From: Stuart Corbey
Sent: 04 October 2018 15:16
To: Karen Parsons
Subject: FW: EG/43/18/PL - 42 Barnham Road, Eastgate.

Further to my phone message of today I would like to confirm we are minded to permit the change of use, subject to some restrictions.

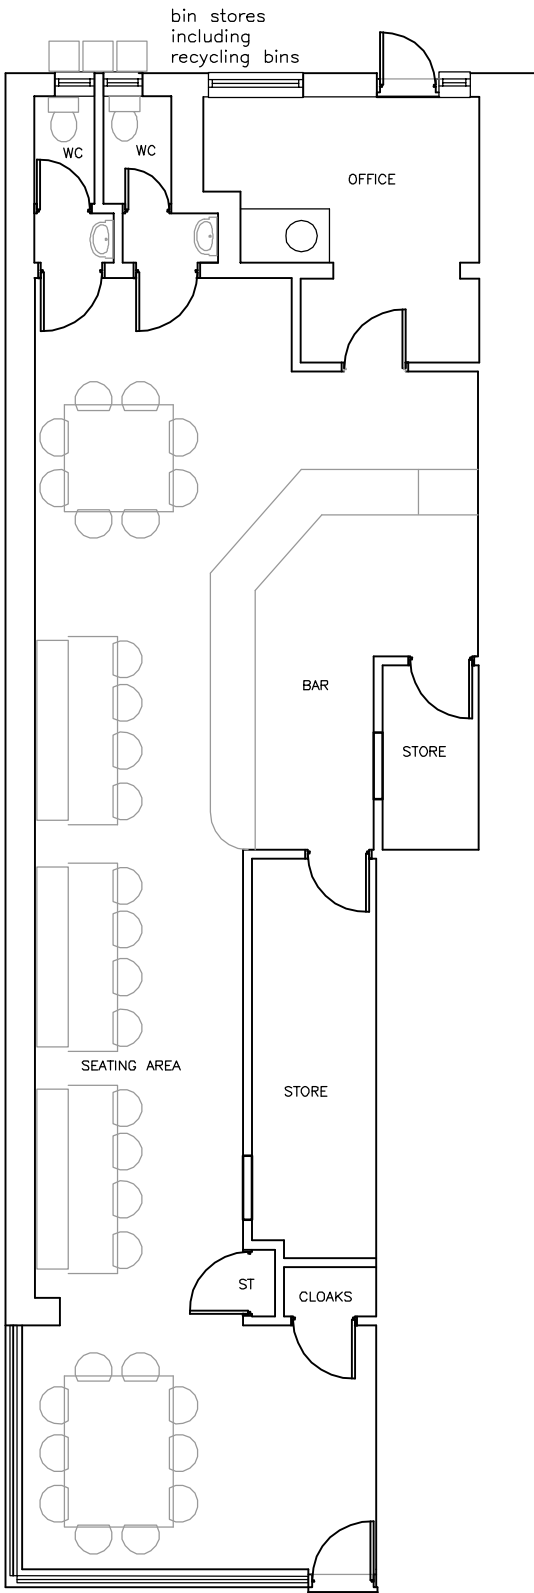
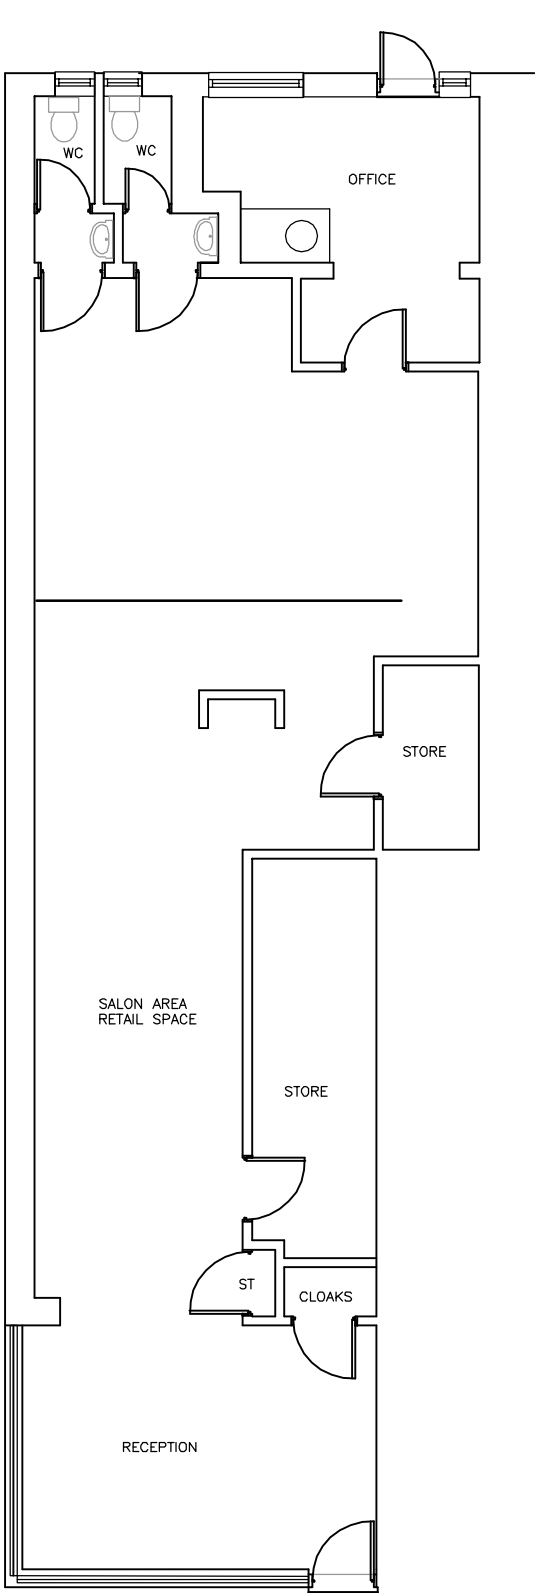
The Councils' Environmental Health Officer from their comments of 15th August could not agree to the x8 outside seating arrangement due to the impact on the immediate amenity of neighbouring occupiers. In addition the hours of operation at the premises would need to be restricted to 10pm to limit the harm to occupants of nearby residential properties.

If you could amend plan 267/02 to omit the external seating and agree to an Extension of Time to Friday 5th October we can have a decision on it way.
